Proposed Basement Flats at 102 & 104 Sackville Street, Barnsley

We enclose two copies of revised drawing 08-066-04A and we trust this is satisfactory.

BASEMENT PLAN - AS PROPOSED

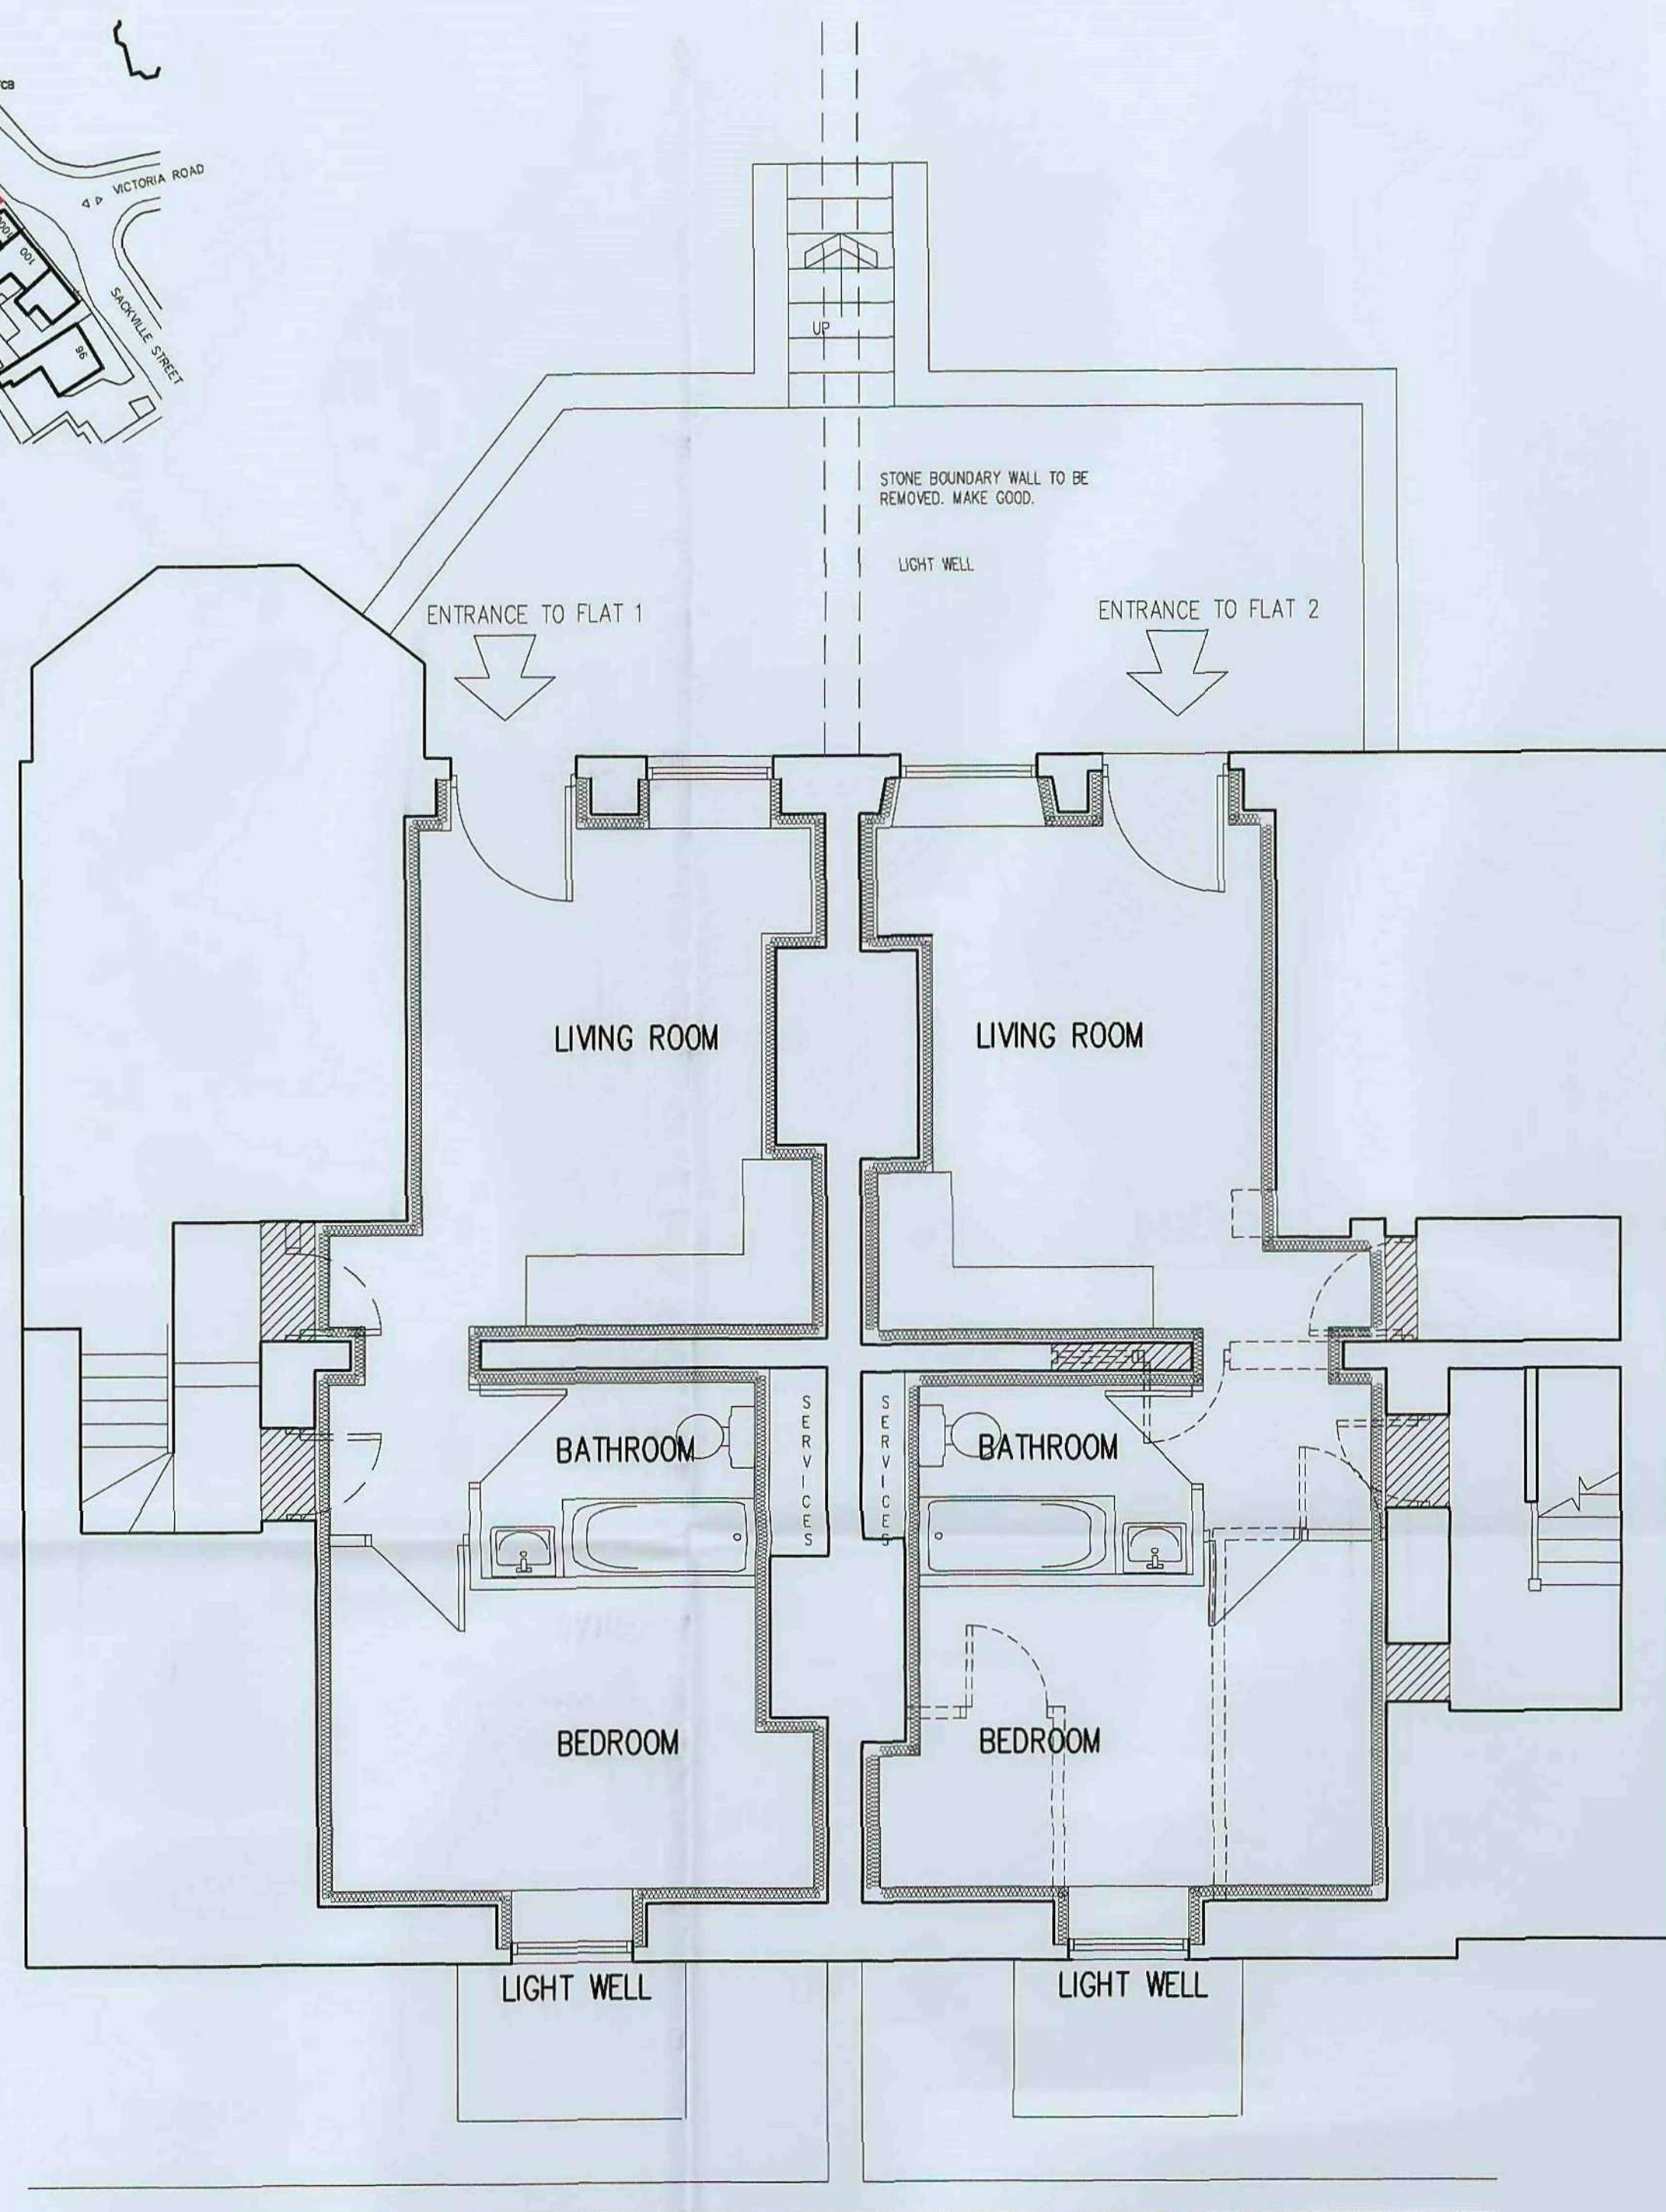
1. It is intended that the existing covered entrance adjacent 102 Sackville Street will be retained as a pedestrian access to both flats. A suitable entry system to allow residents and visitors will be provided to allow access to the rear garden and basement flats.
2. As discussed a light-well will be provided to the rear to improve the general amenity of both basement flats.
